Subject: Eagle Rising SF2225 Plat Filing 1 Response Letter and EDARP Upload

Our responses to the EPC August 15, 2024 Plat and related documents review comments and the Applicant team and EPC staff September 4, 2024 review meeting have been uploaded EDARP.

Submittal N	EDARP Review Comments	8.15.2024	Applicant Response spreadsheet Date	9.10.2024														
Project Name	Eagle Rising Final Plat Filing No. 1 (Minor) SF2225

DRAINAGE EASEMENT DETAILS
 LOTS 3 & 6
 SCALE: 1" = 50'

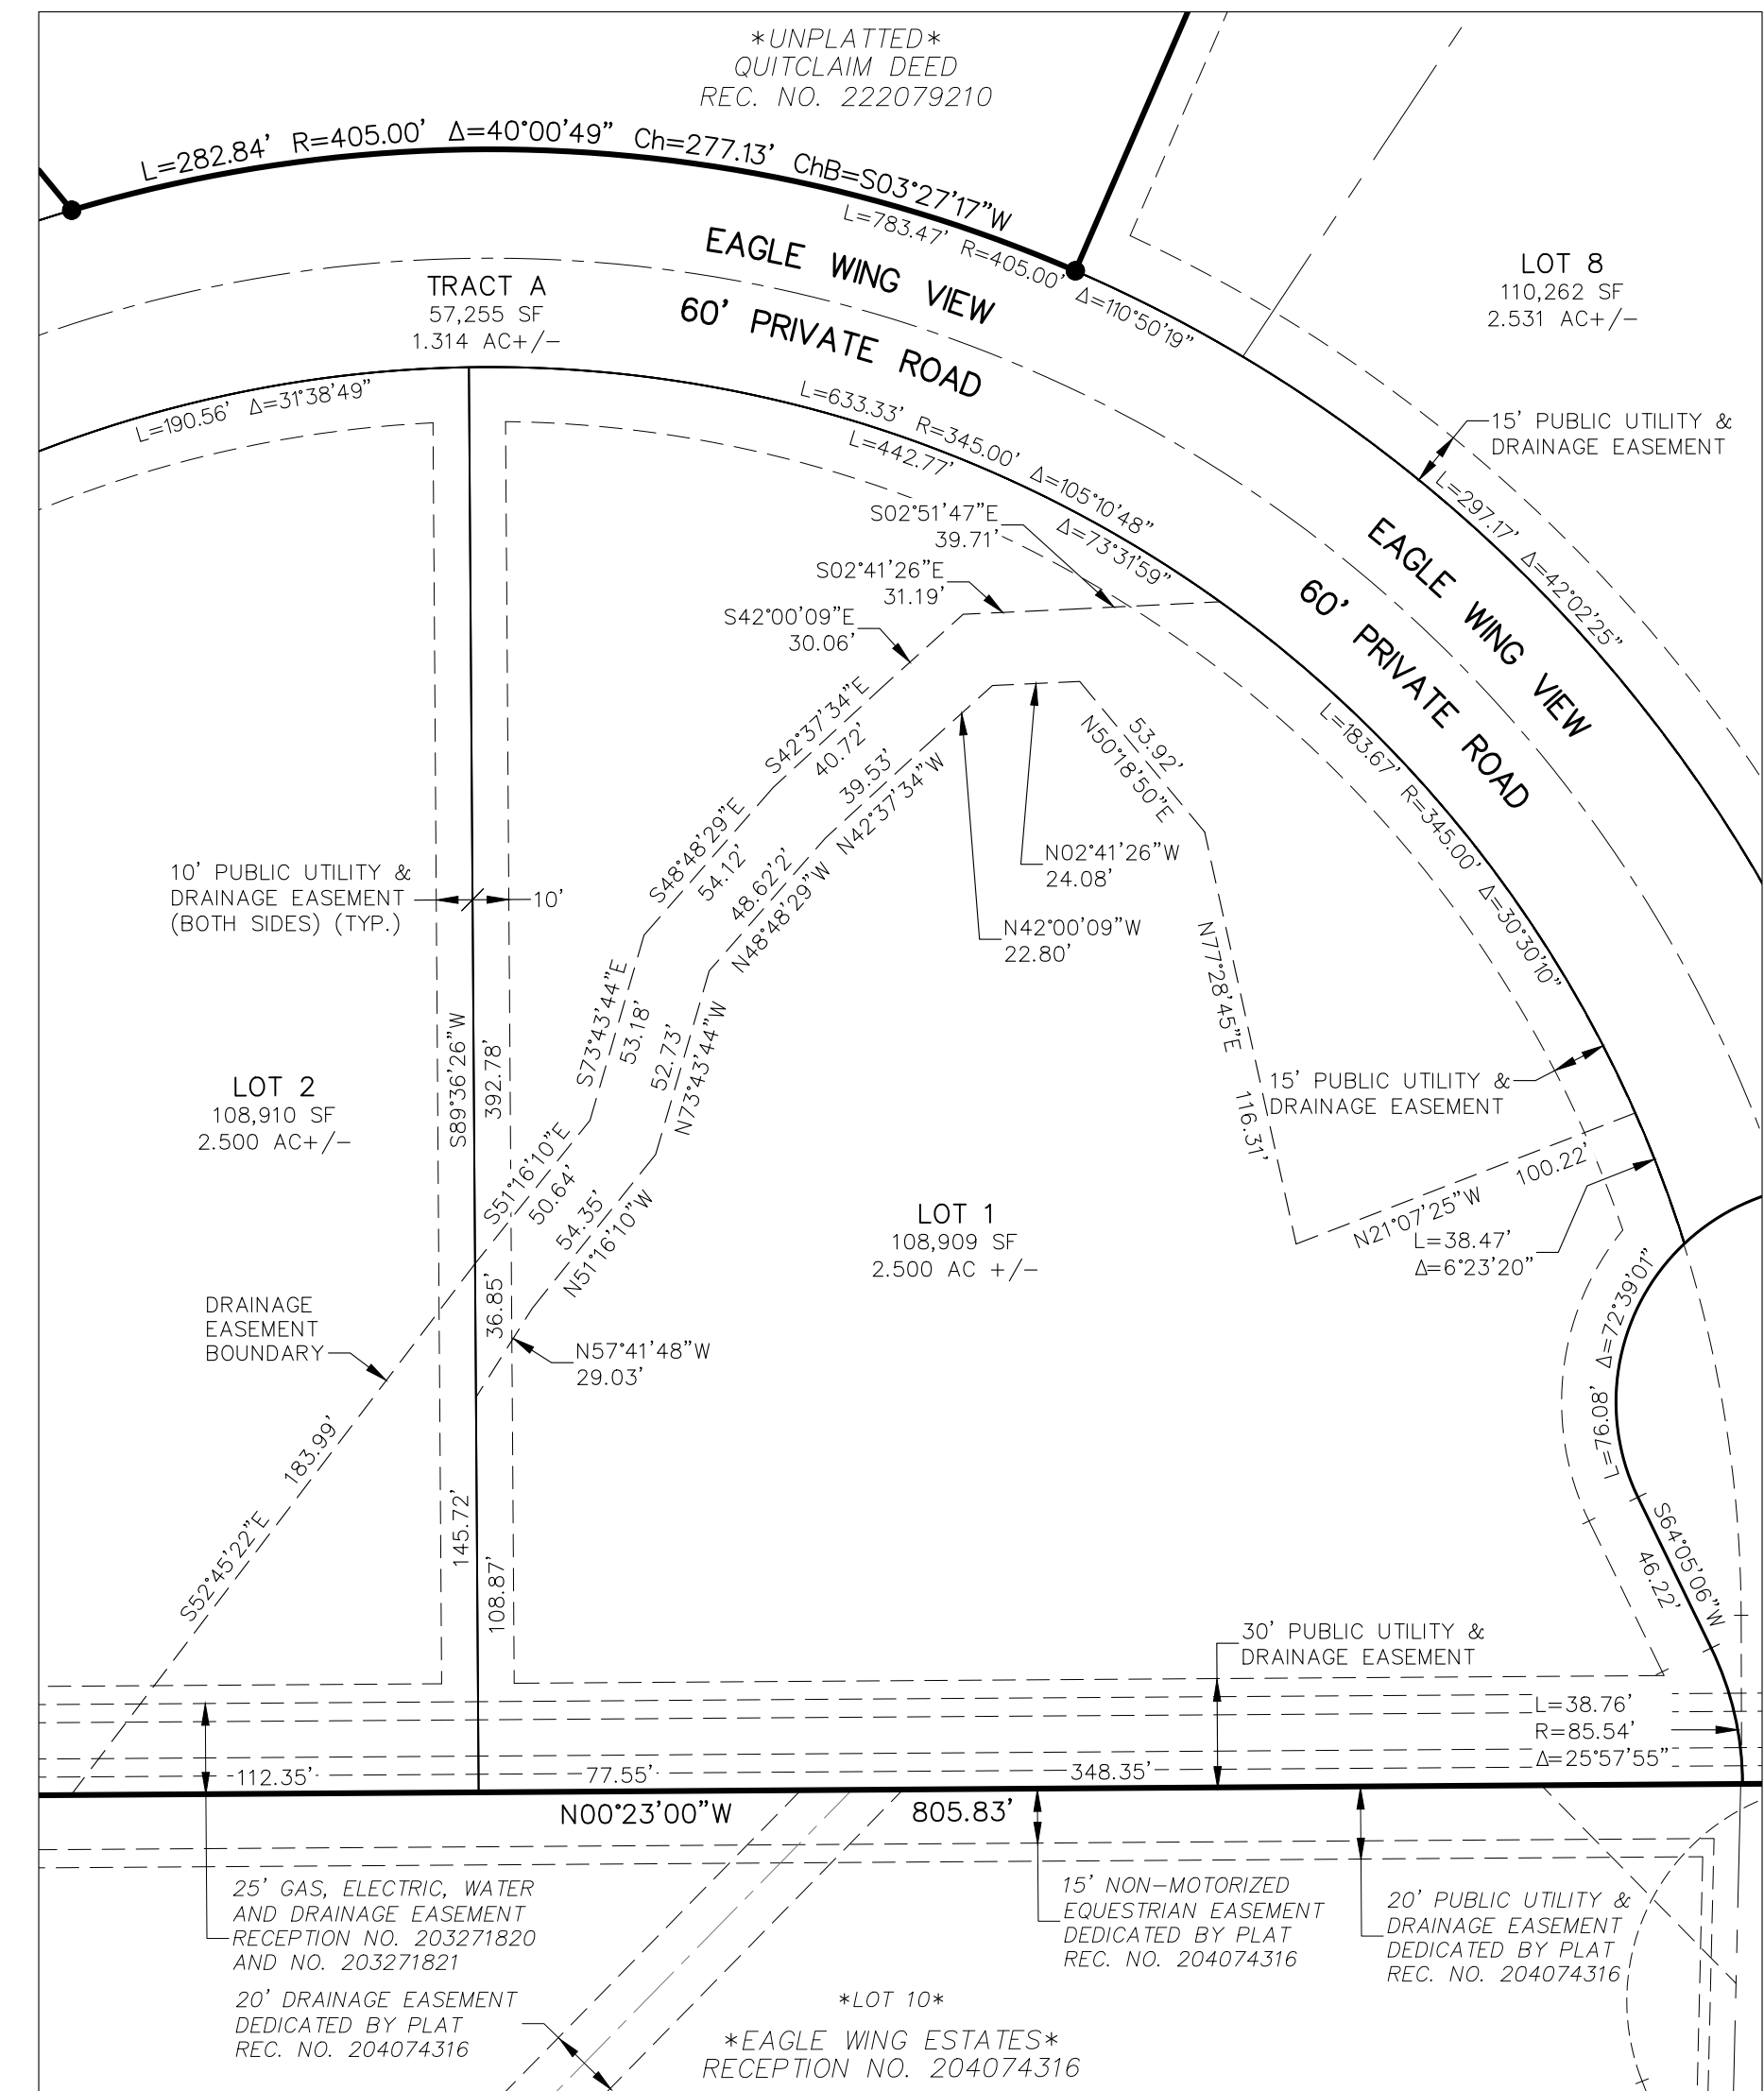
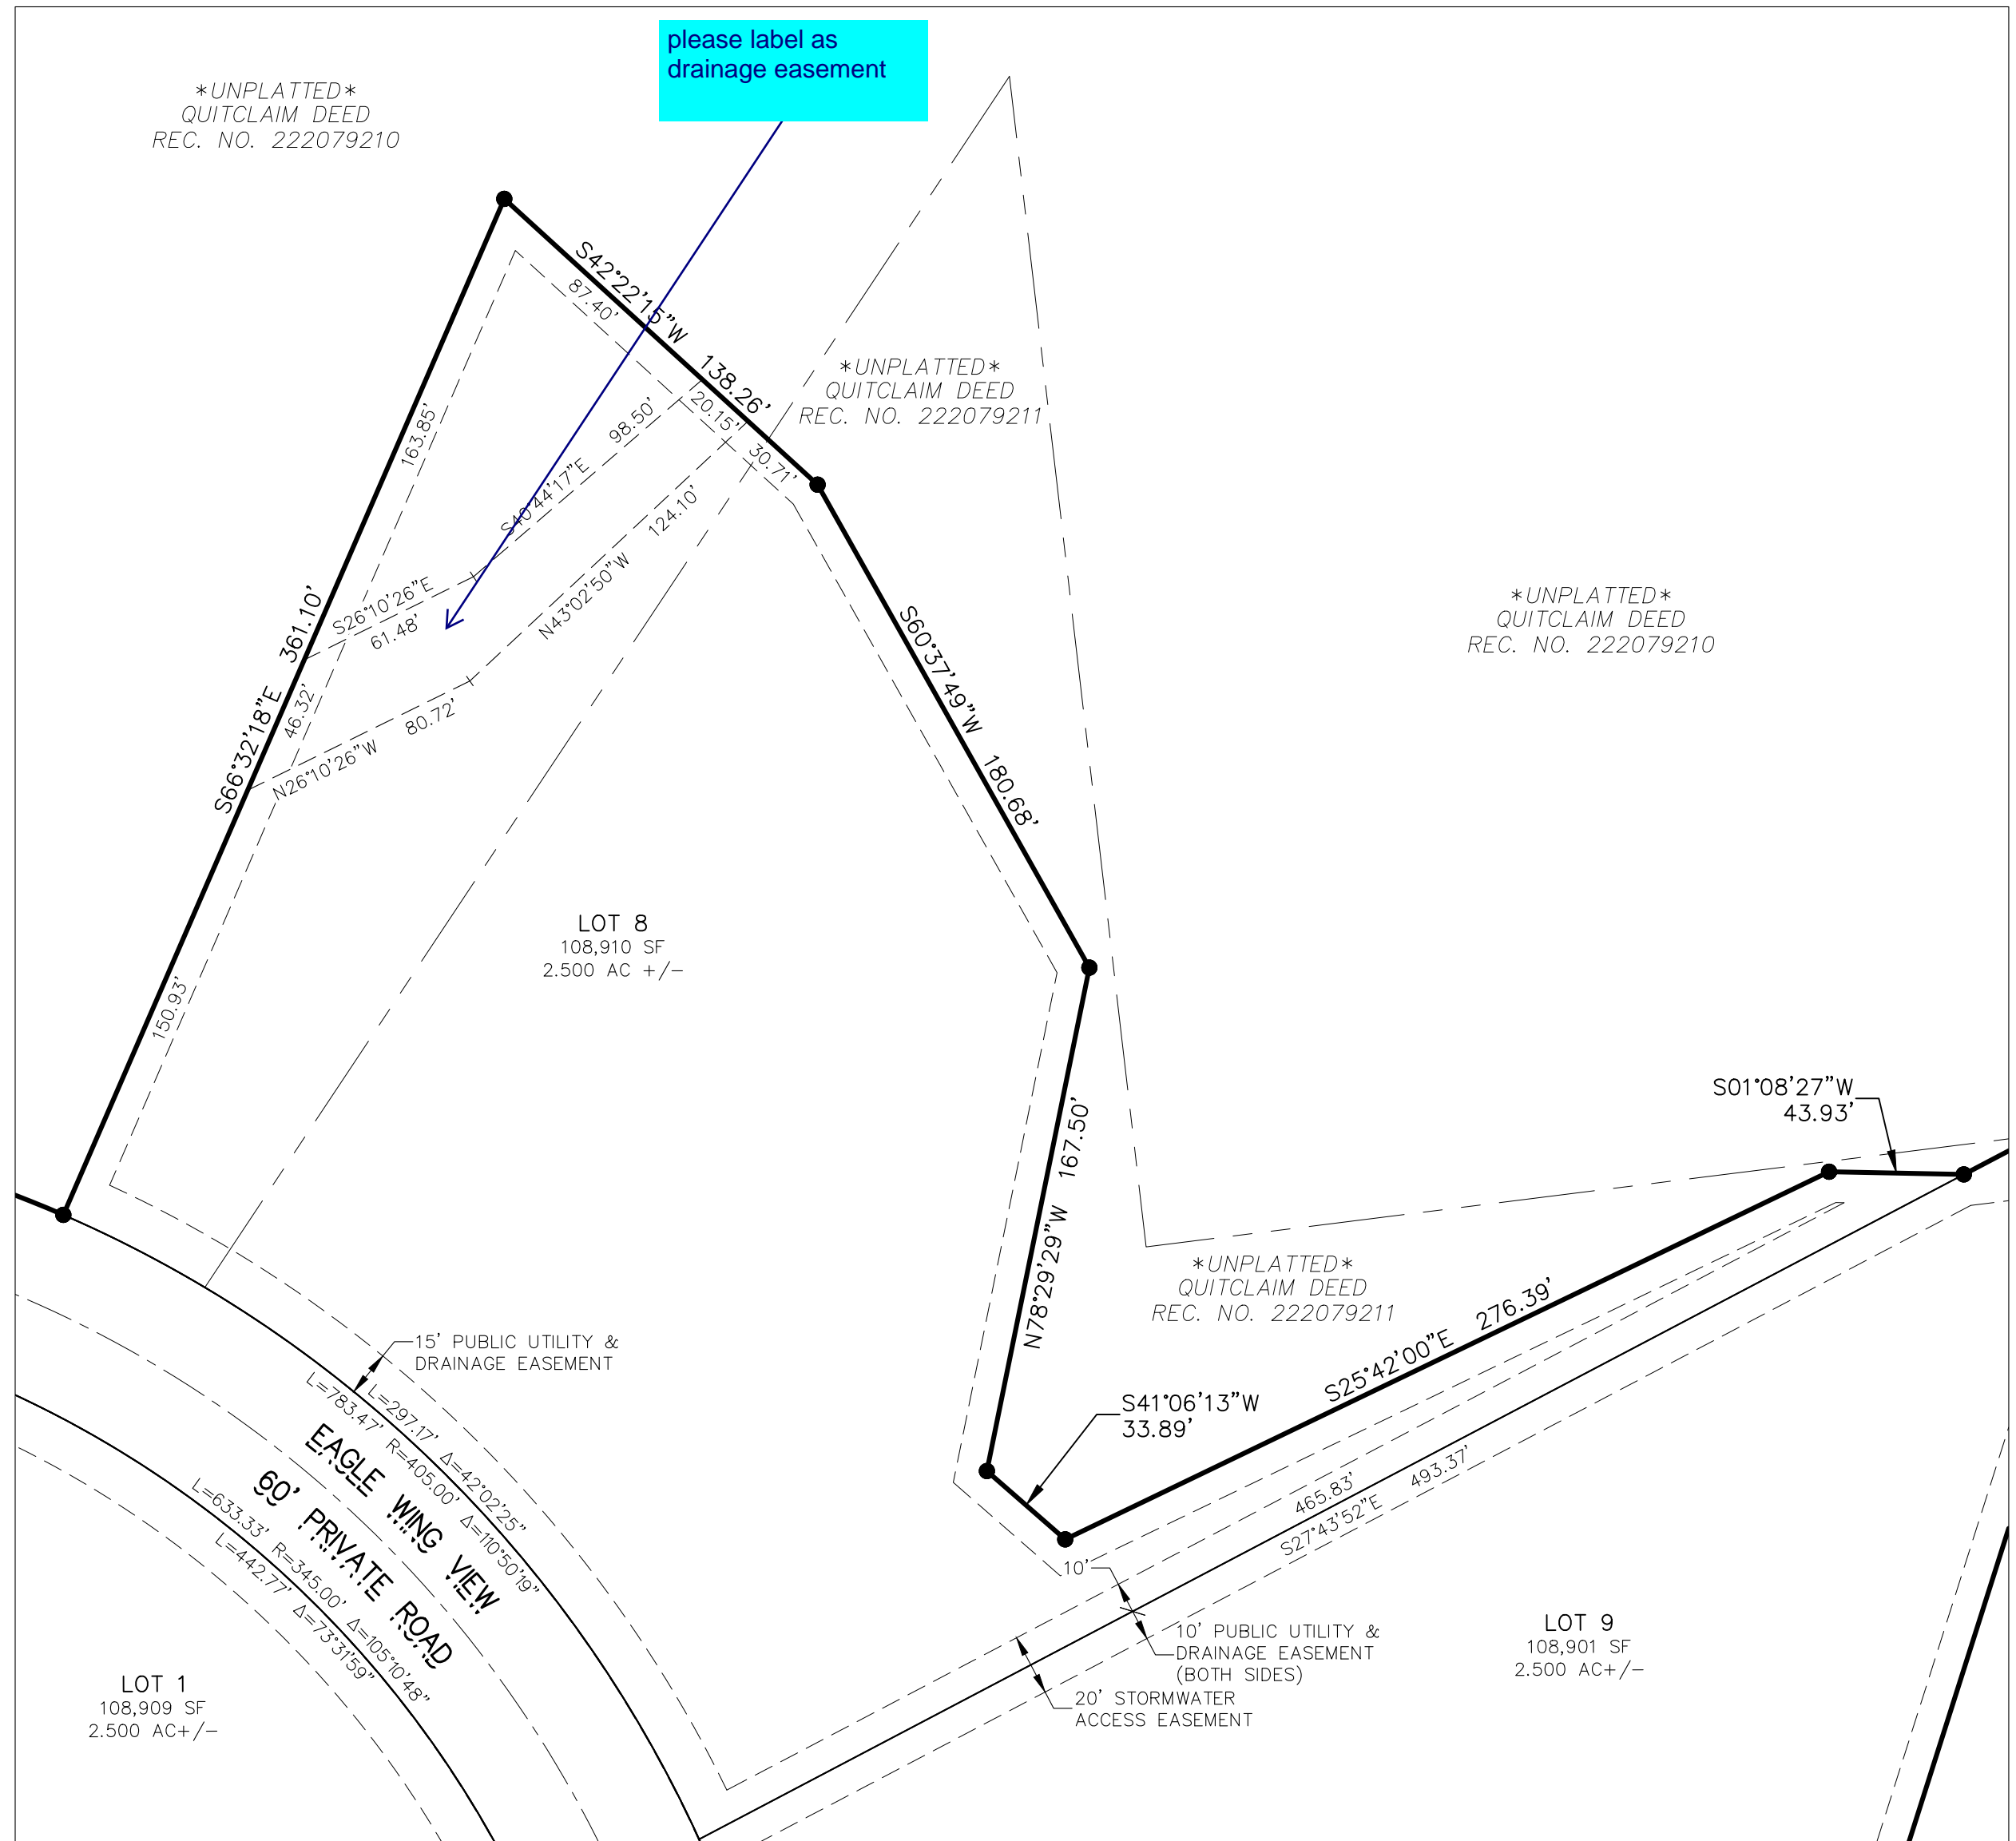
24	Final Plat Eagle Rising Filing No 1	PCD Engineering Division	Yes	Jeff Rice	8/15/2024 16:12	(Plat redlines)	2	provide drainage easement	A - Approve	9/17/2024	Final Plat Eagle Rising Filing No 1	4	Added					
25	Final Plat Eagle Rising Filing No 1	PCD Engineering Division	Yes	Jeff Rice	8/15/2024 16:12	(Plat redlines)	2	Provide drainage easement per FDR comments	A - Approve	9/17/2024	Final Plat Eagle Rising Filing No 1	5	Added					
26	Final Plat Eagle Rising Filing No 1	PCD Engineering Division	Yes	Jeff Rice	8/15/2024 16:12	(Plat redlines)	2	Is property boundary going to be adjusted prior to platting?	E - Answer provided	9/17/2024	Final Plat Eagle Rising Filing No 1	-	Boundary lines will be adjust prior to recording after Final Plat approval .					
27	Final Plat Eagle Rising Filing No 1	PCD Engineering Division	Yes	Jeff Rice	8/15/2024 16:12	(Plat redlines)	2	label acreage	A - Approve	9/17/2024	Final Plat Eagle Rising Filing No 1	2	Added

45	Eagle Rising Filing No 1 Final Drainage Report	PCD Engineering Division	Yes	Jeff Rice	6/6/2024 10:41	(FDR redlines)	212	Provide drainage easement and analysis based on revisions to report	E - Answer provided	9/17/2024	Eagle Rising Filing No 1 Final Drainage Report	-	Added Drainage easement and coordinated with plat drawing
